Consultation Response from KC, Highways Development Management (HDM)

2023/93539 Land adjacent to Ledgard Bridge Mill, Back Station Road, Mirfield, WF14 8NZ

Outline application, including the considerations of access, appearance, layout, and scale, for the erection of a six-storey building to host 76 residential apartments (C3 use) and ancillary works comprising demolition of vacant building, formation of new access, parking areas, open space and landscaping; erection of cycle and bin refuse storage structures.

Date Responded: 26/02/24

Car Park Plan (part) 1: 200

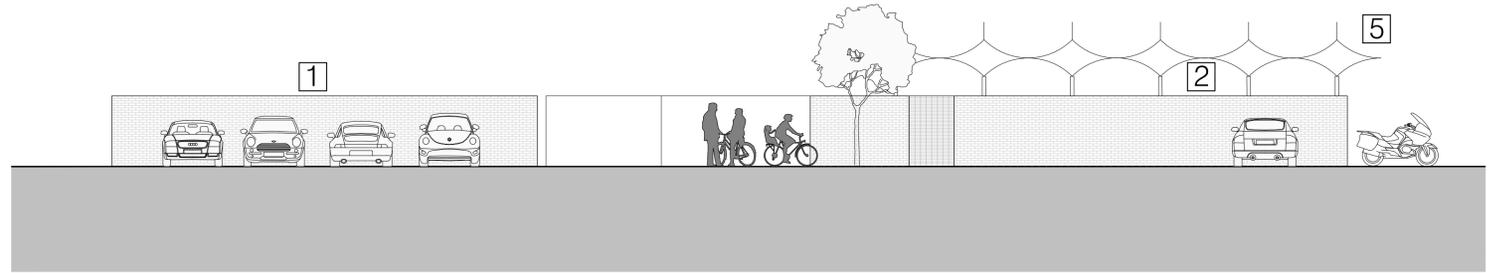
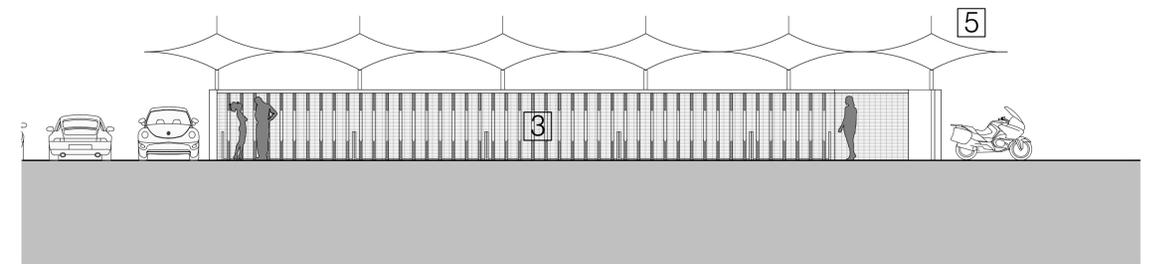
Therefore, it is considered that additional cycle parking should be provided within the hub building that can be used for all residents at the site. This could be achieved without enlarging the cycle hub building if double stacking cycle racks were used. This appears to be possible subject to a minimum height clearance being available of circa 2.6m (and some systems can work with a slightly lower height clearance if necessary).

The cycle hub also does not include any provision for non-standard cycle types, such as cargo bikes, tricycles or adapted cycles. Therefore, the current design does not provide an inclusive provision for all users groups, and should be reviewed.

EV Charging Wall Elevation 1: 100

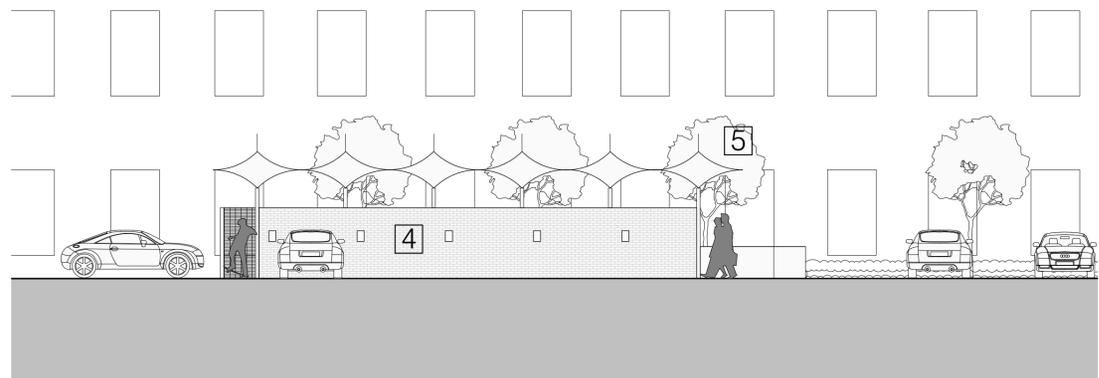
With regard to the design of the EV charging spaces, there does not appear to be space to locate a charging unit in the spaces located next to the cycle parking hub building. If the EV unit is fixed to the wall of the hub, this is likely to result in cars not being able to park fully within the car parking spaces. Therefore, further consideration of the EV parking space designs are required, which include details of the charging unit locations.

No EV charging facilities have been shown for the disabled car parking spaces, and this issue should also be addressed.

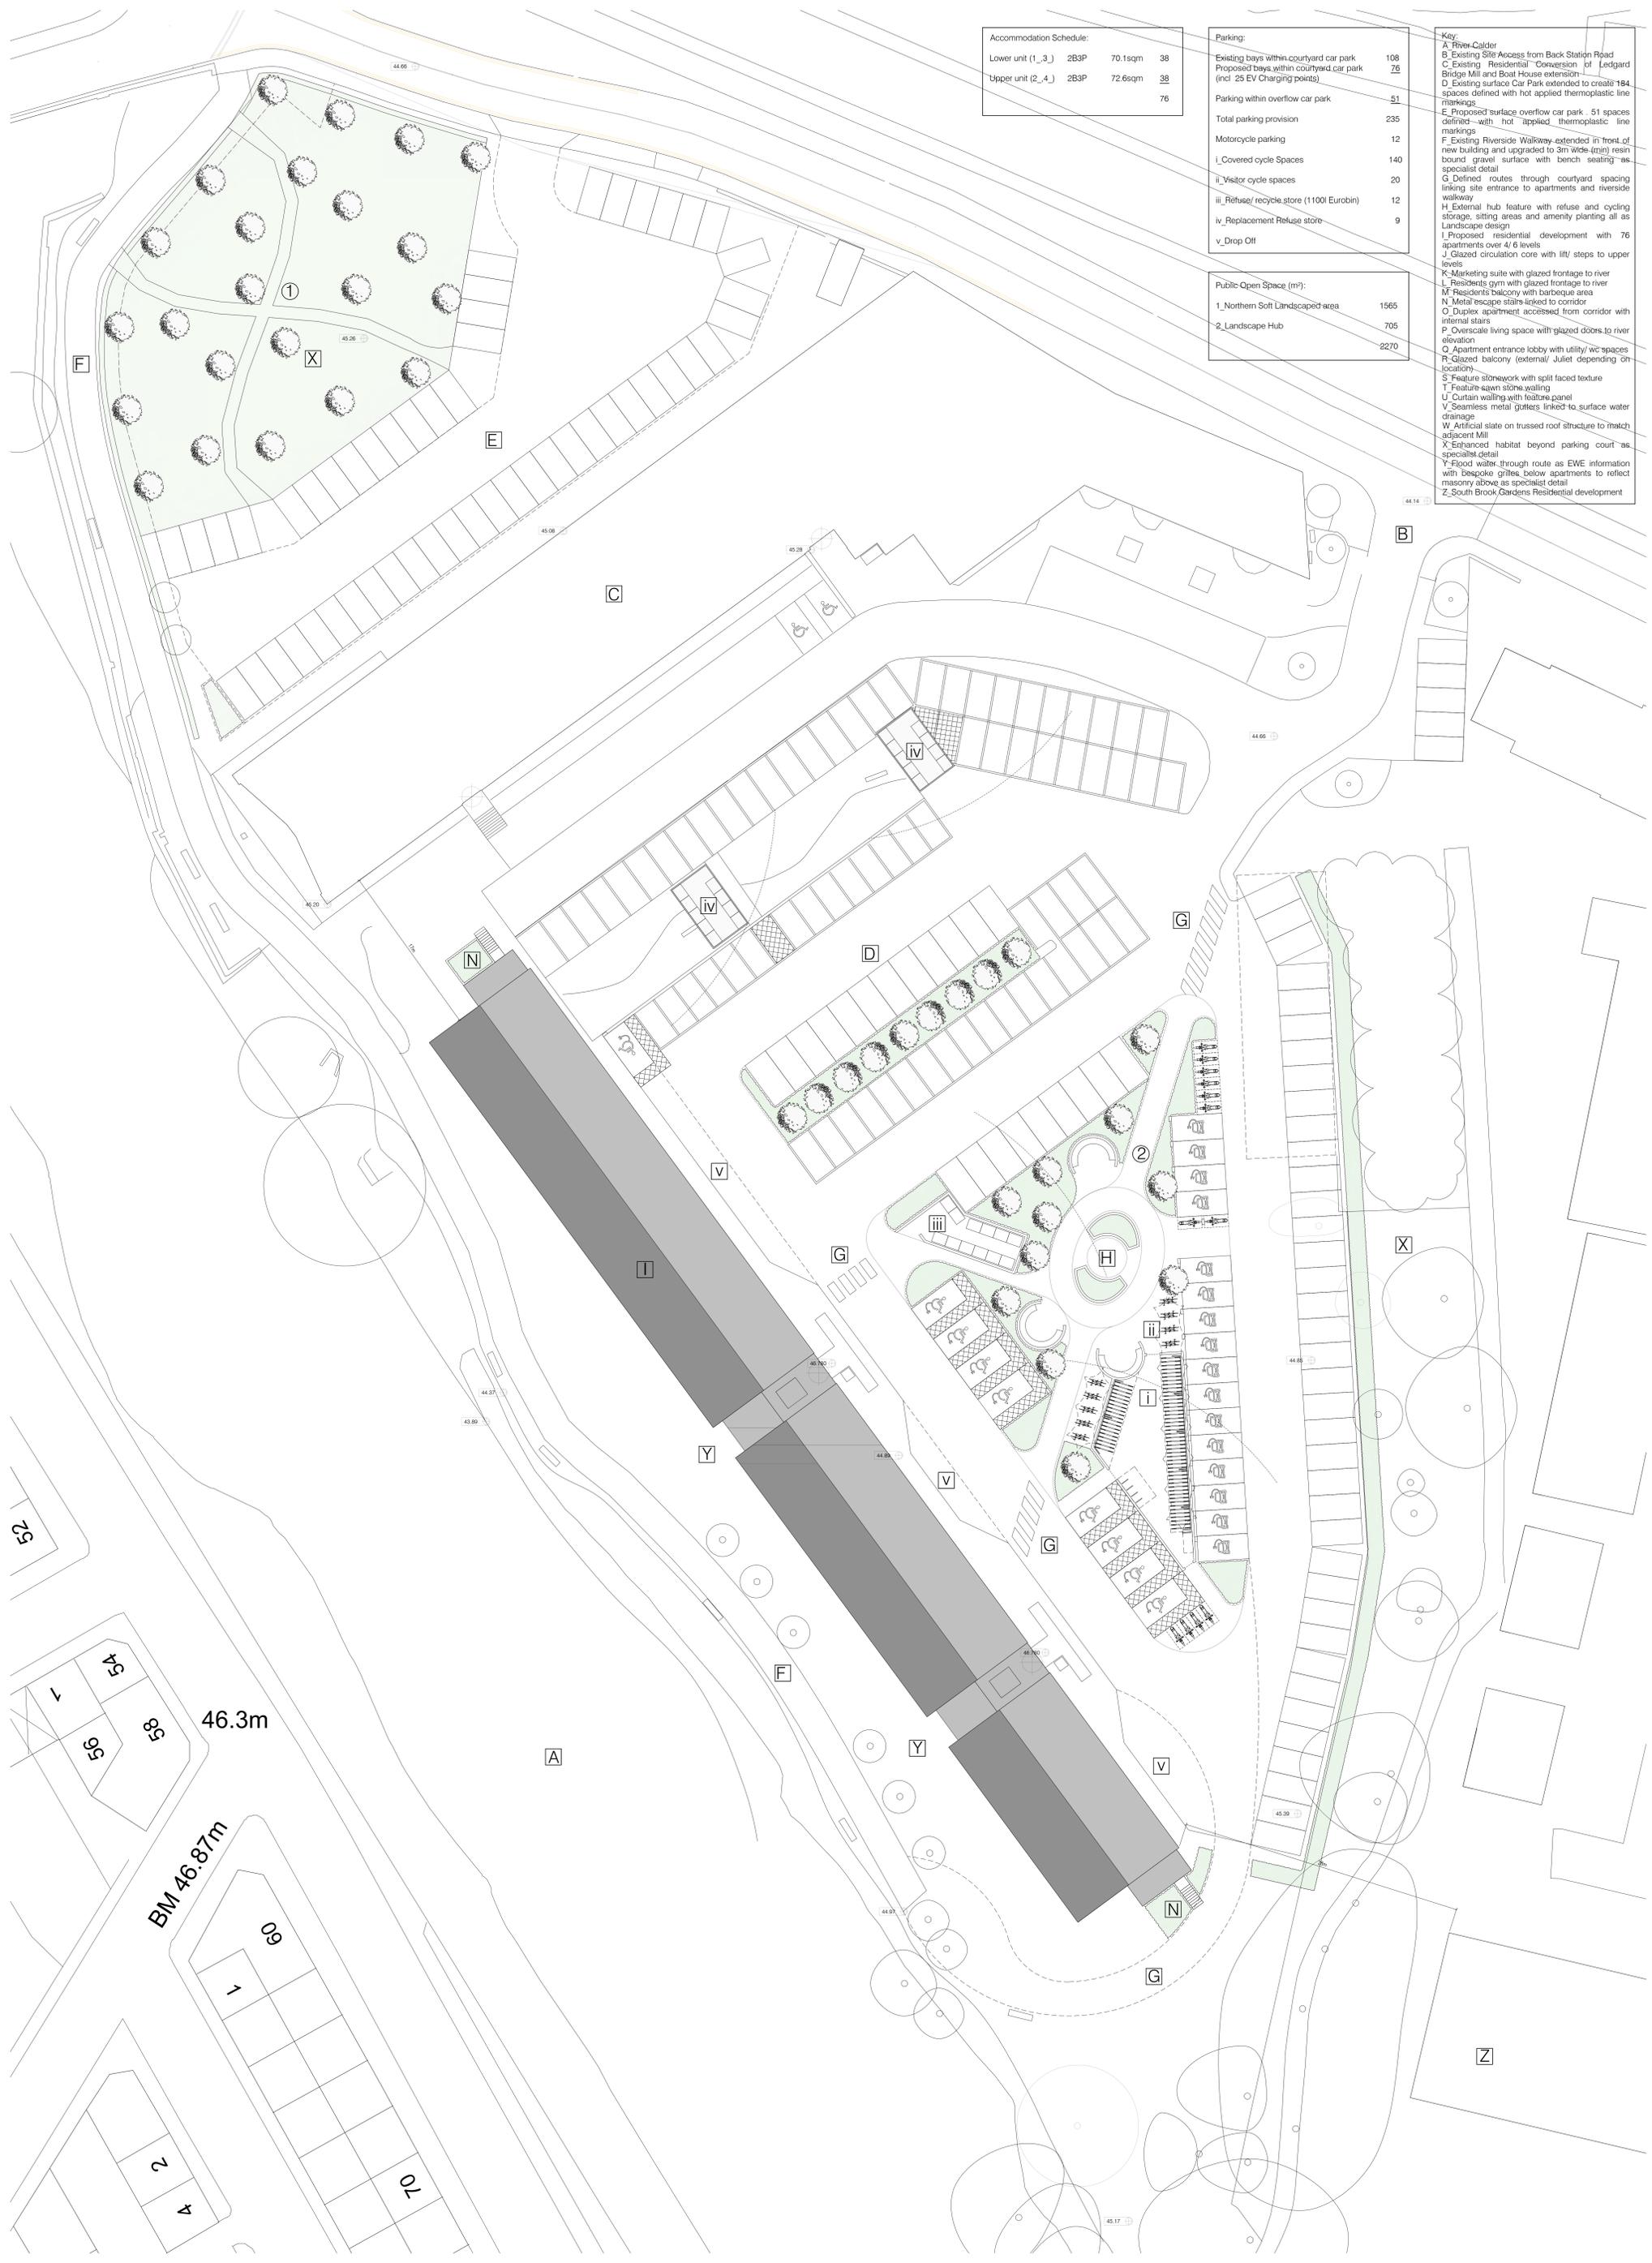
With regard to the junction visibility splays, the landscaping and parking bays within the overspill park currently block the visibility splays. Therefore, in the revised access design, the boundary fence and landscaping needs to be set back to the rear of the visibility splays. This should also be reflected on all other submission drawings, including the site layout plan.

However, there are two replacement waste stores marked 'iv' on the site plan, which appear to be remote from the proposed layby. As such, this will add significant time and effort for waste collection personnel and appear to be beyond normally acceptable bin carried distances. Therefore, further information/amendments are required to the sites waste strategy, to ensure that it complies with the Councils Waste Management Team requirements. Consideration also needs to be given to how waste will be managed during the construction process, as the Councils waste teams will not enter construction sites.
